**re: Grading Plan and Civil Engineering Design – Geotechnical Review
Proposed Low-Rise Residential Development
3040 & 3044 Innes Road – Ottawa, Ontario**

date: November 2, 2023

file: PG5763-MEMO.02

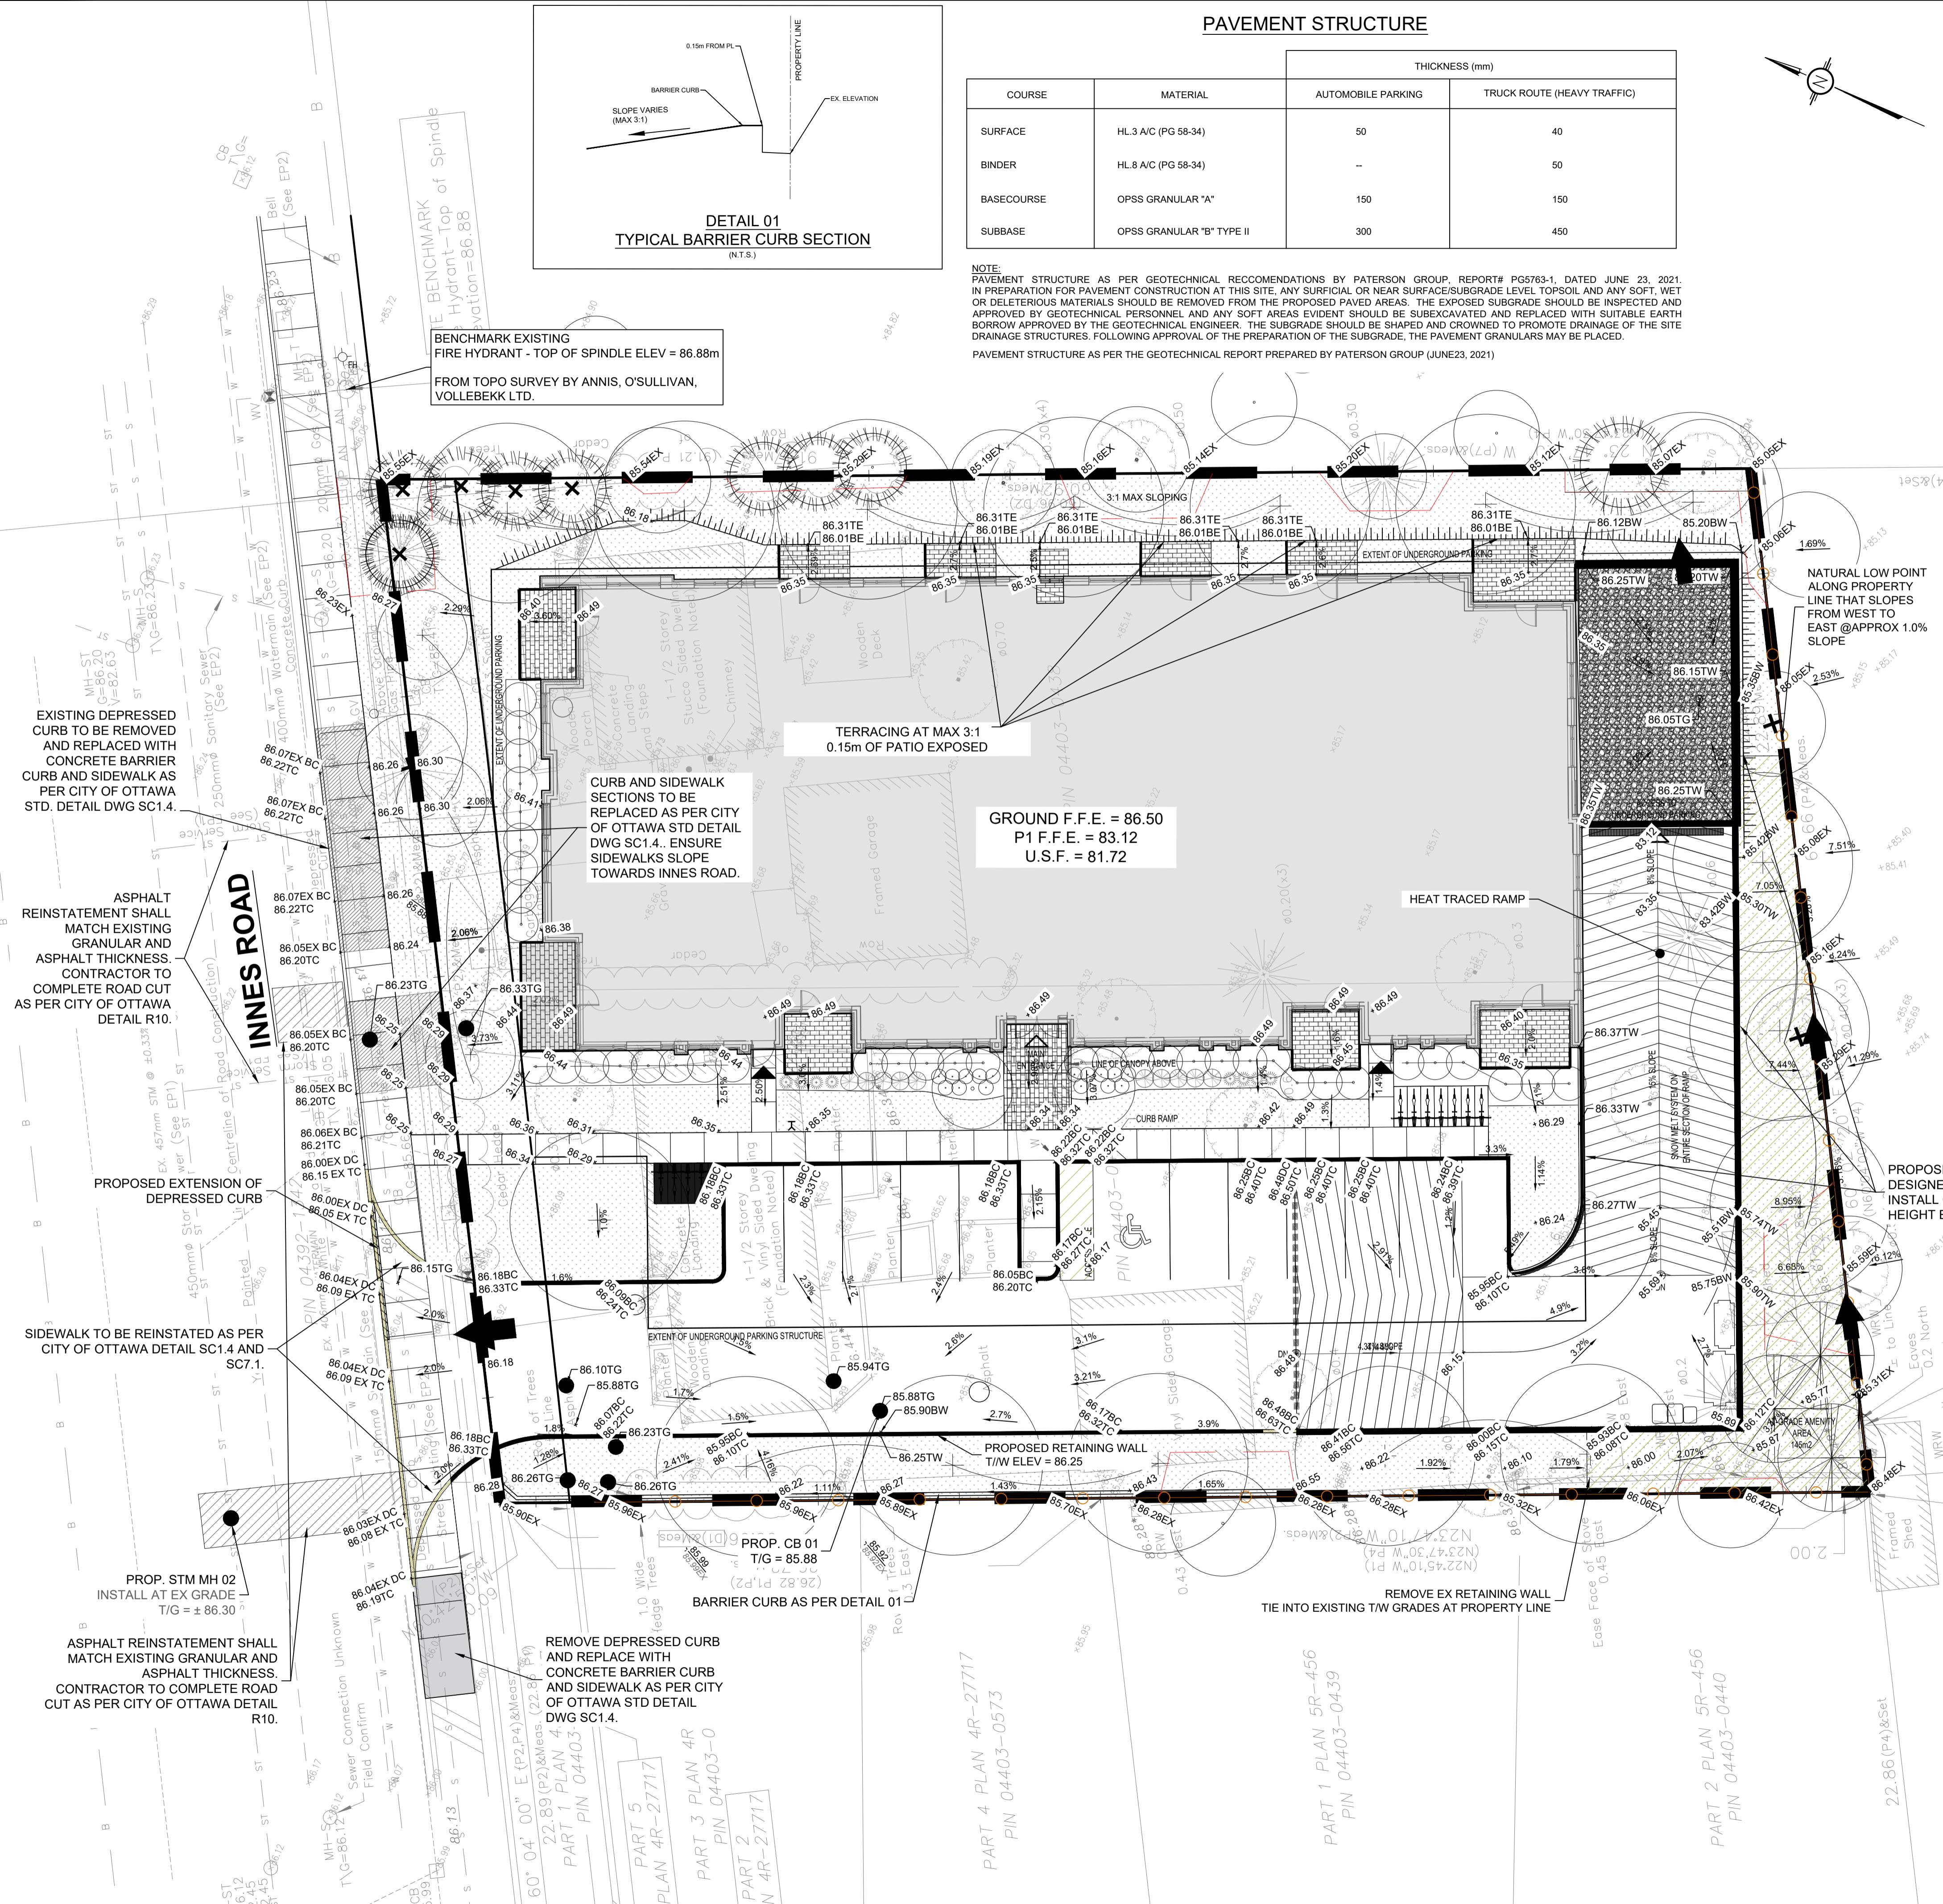
- Project No. 210374 – Grading and Drainage Plan – Drawing No. C301, Revision 5 dated October 23, 2023.
- Project No. 210374 – Servicing Plan - Drawing No. C401, Revision 5 dated October 23, 2023.

Based on our review of the above noted drawing, all proposed grading for the subject development is in accordance with the recommendations of the geotechnical report. Therefore, the proposed grading is considered acceptable from a geotechnical perspective and no lightweight fill will be required for the proposed building.

PROJECT NO: 210374, DATE: OCTOBER, 2023, C401

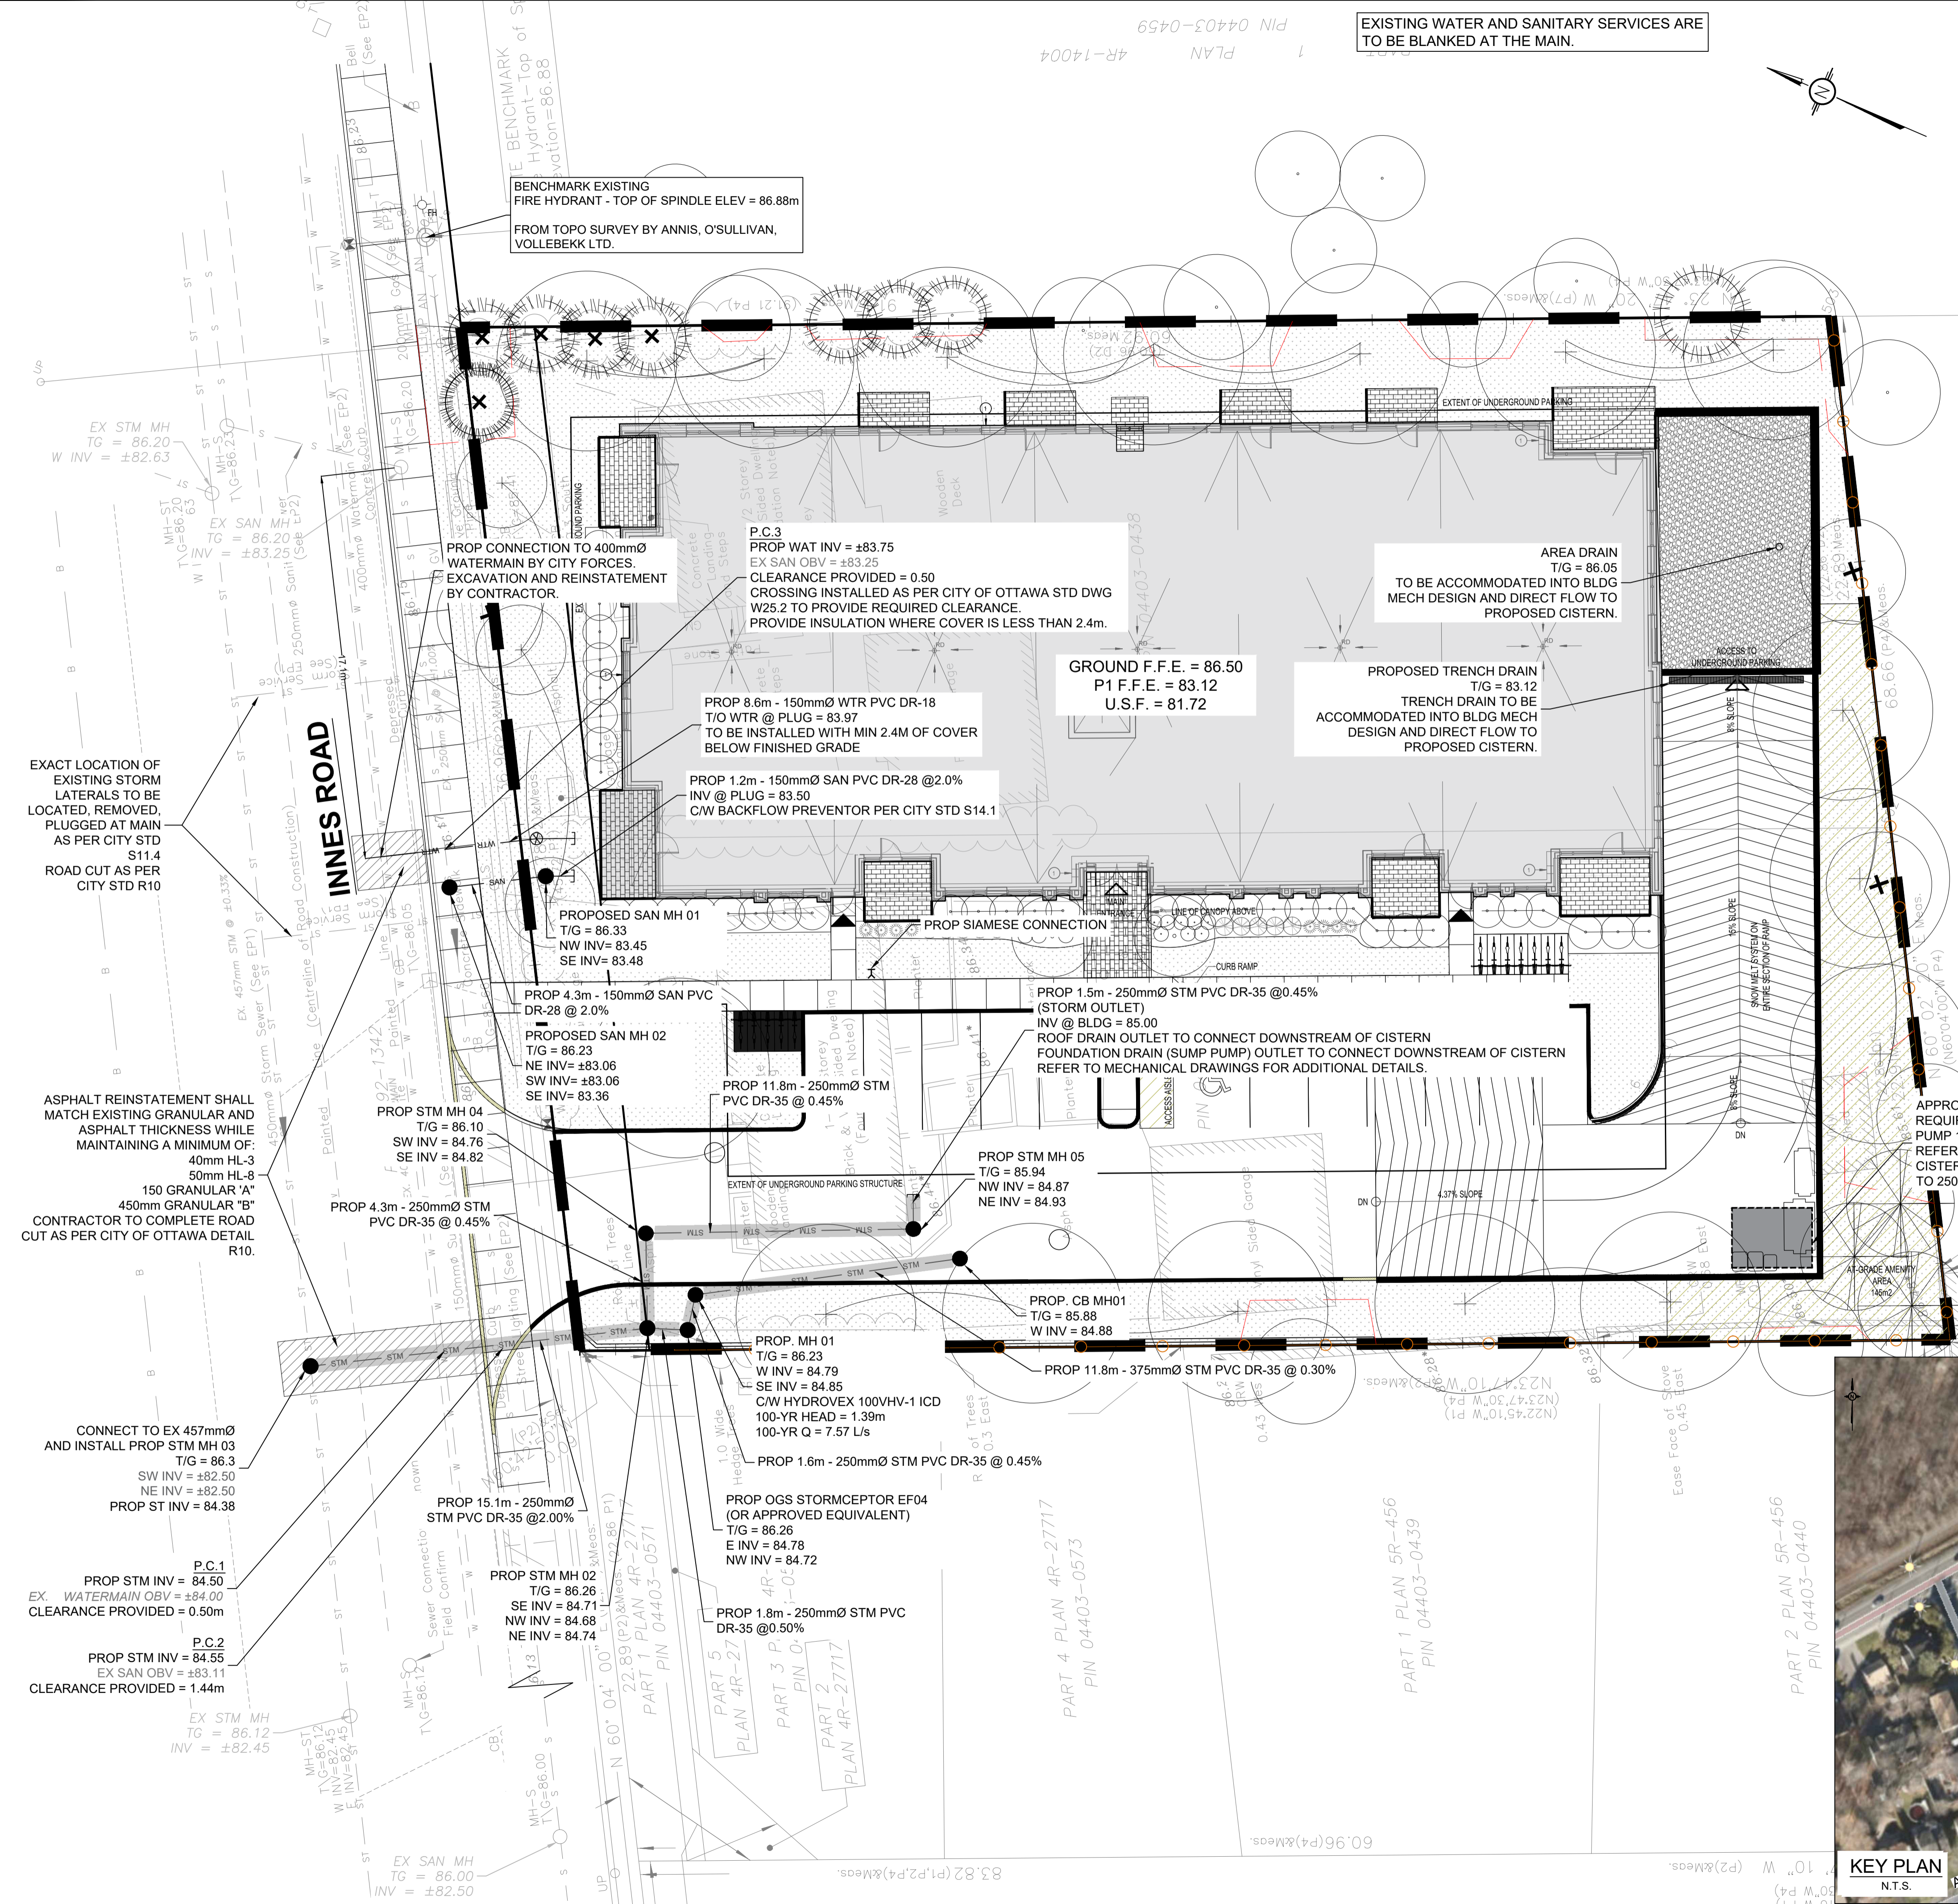
Furthermore, the maximum depths of the proposed services are higher than the proposed buildings underside of footing (USF). Therefore, installation and/or maintenance of the servicing will not impact the building's lateral support. The proposed servicing is in accordance with the recommendations of the geotechnical report and is considered acceptable from a geotechnical perspective.
